**WELWYN HATFIELD BOROUGH COUNCIL  
EXECUTIVE DIRECTOR - PLANNING, PUBLIC PROTECTION AND GOVERNANCE**

**Application No:** 6/2022/0583/LAWP  
**Location:** Coverack 50 The Ridgeway Cuffley Potters Bar Hertfordshire EN6  
4BA

**Proposal:** Certificate of lawfulness for two single storey side extensions  
**Officer:** Ms Elizabeth Mugova

**Recommendation:** Refused

Site address	50 The Ridgeway Cuffley EN6 4BA
Project Description	Side Extension
Drawing Title	Proposed Floor Plan's & Elevation's
Drawn	AA
Checked by	DP
Issued for	Planning Approval
Scale	1:100@A1
Drawing No.	1569_320
Date	March 2022

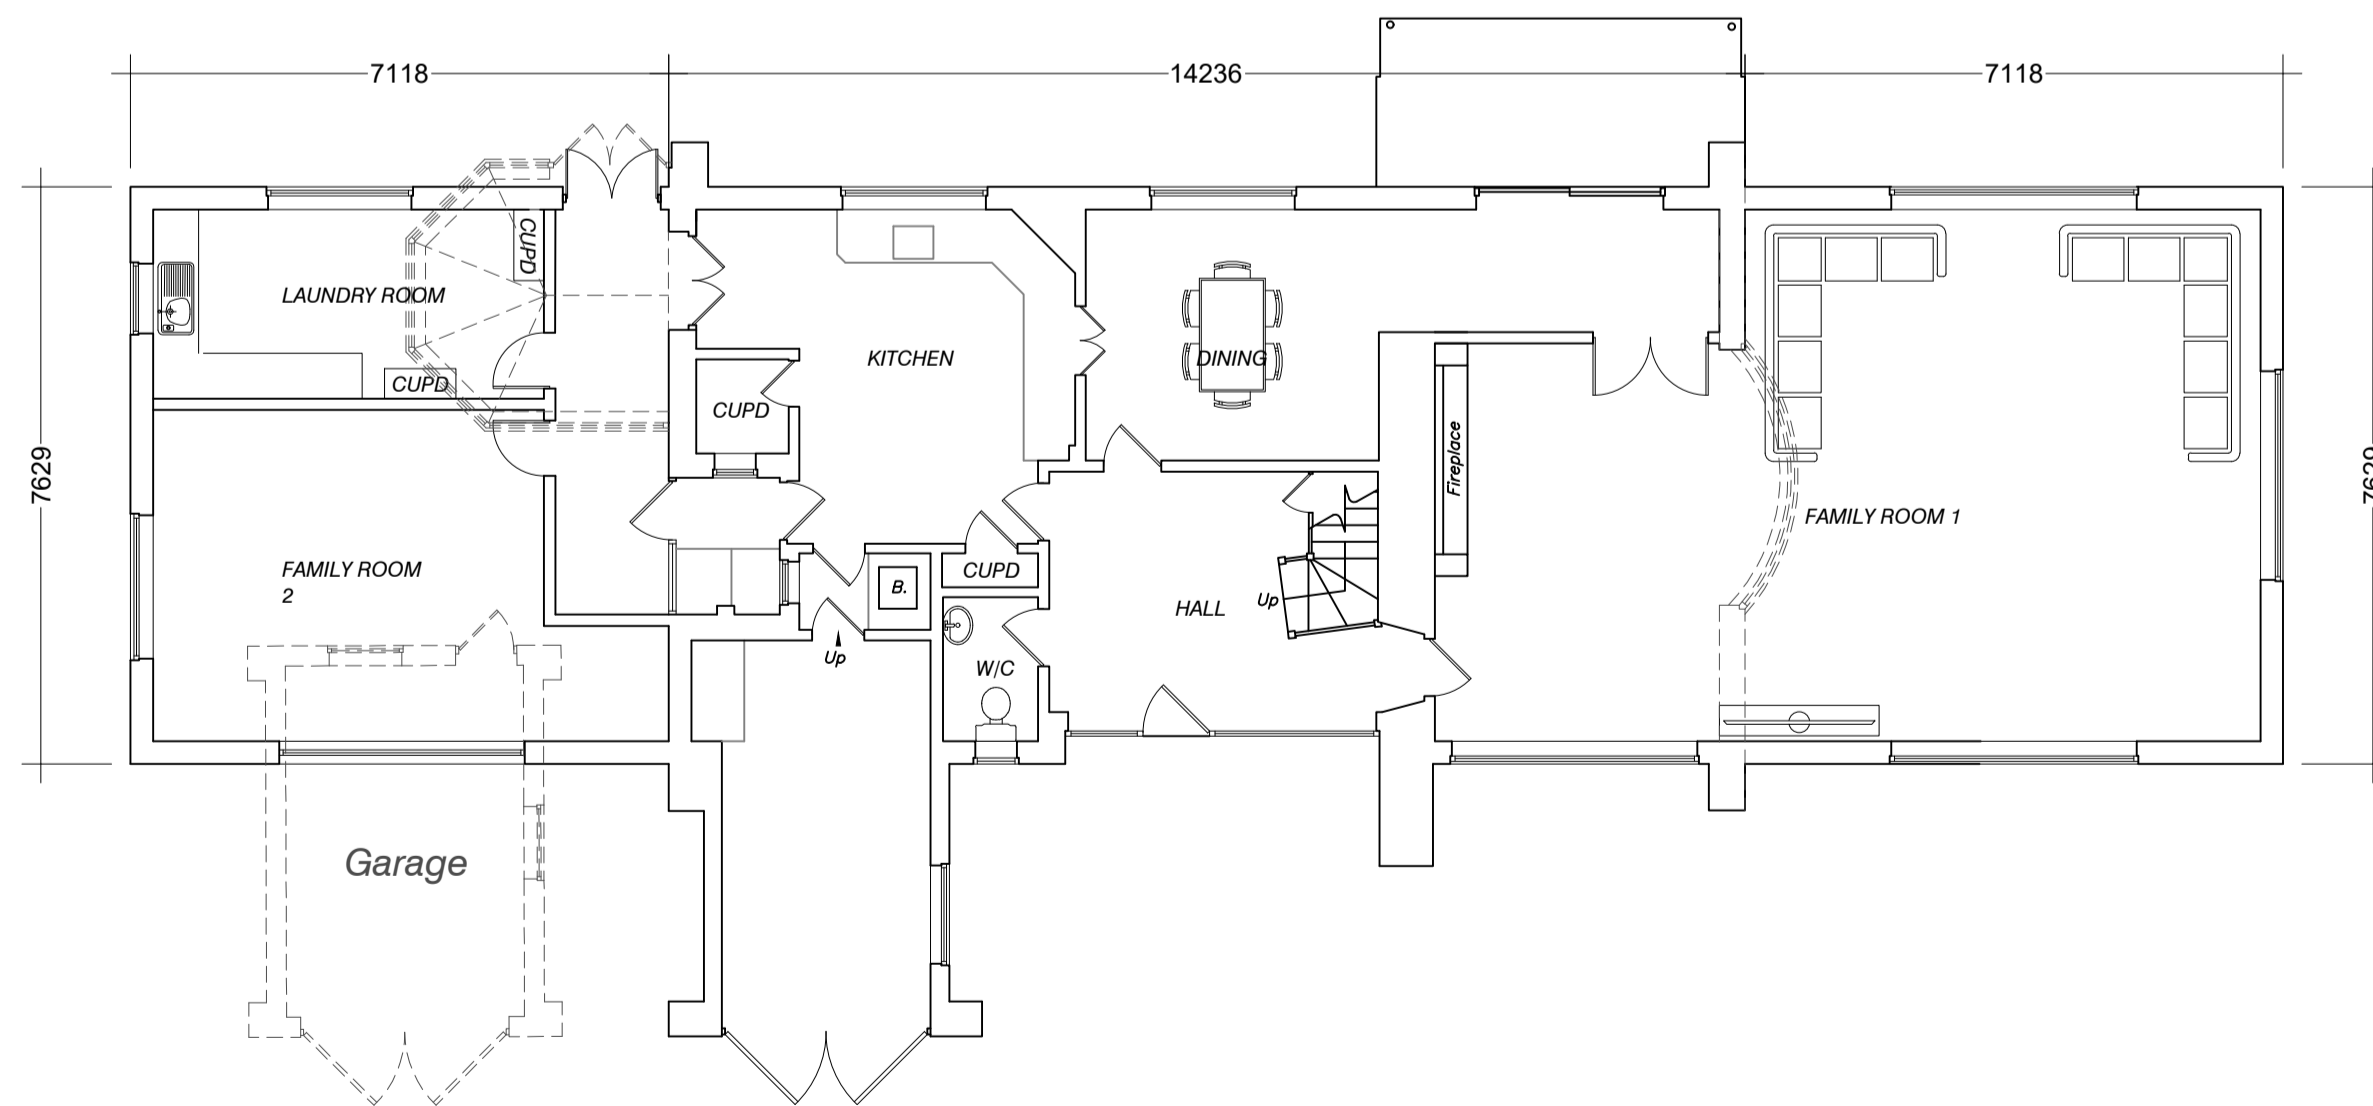
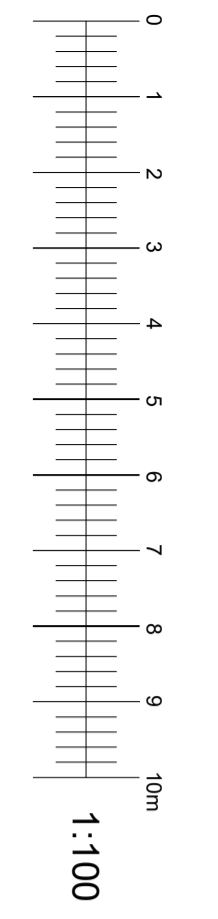
(j) would the enlarged part of the dwellinghouse extend beyond a wall forming a side elevation of the original dwellinghouse, and:- (i) exceed 4 metres in height, (ii) have more than one storey, or (iii) have a width greater than half the width of the original dwellinghouse	<b>Y - the proposed single storey side extensions (combined) would have a width greater than half the width of the original dwellinghouse</b>	N
(ja) any total enlargement (being the enlarged part together with any existing enlargement of the original dwellinghouse to which it will be joined) exceeds or would exceed the limits set out in sub-paragraphs (e) to (j);	N

1. The proposed development fails to comply with the Schedule 2, Part 1, Class A.1(j) of the General Permitted Development Order 2015, as amended. The reason for this is because the proposed extension would have a width greater than half the width of the original dwellinghouse.
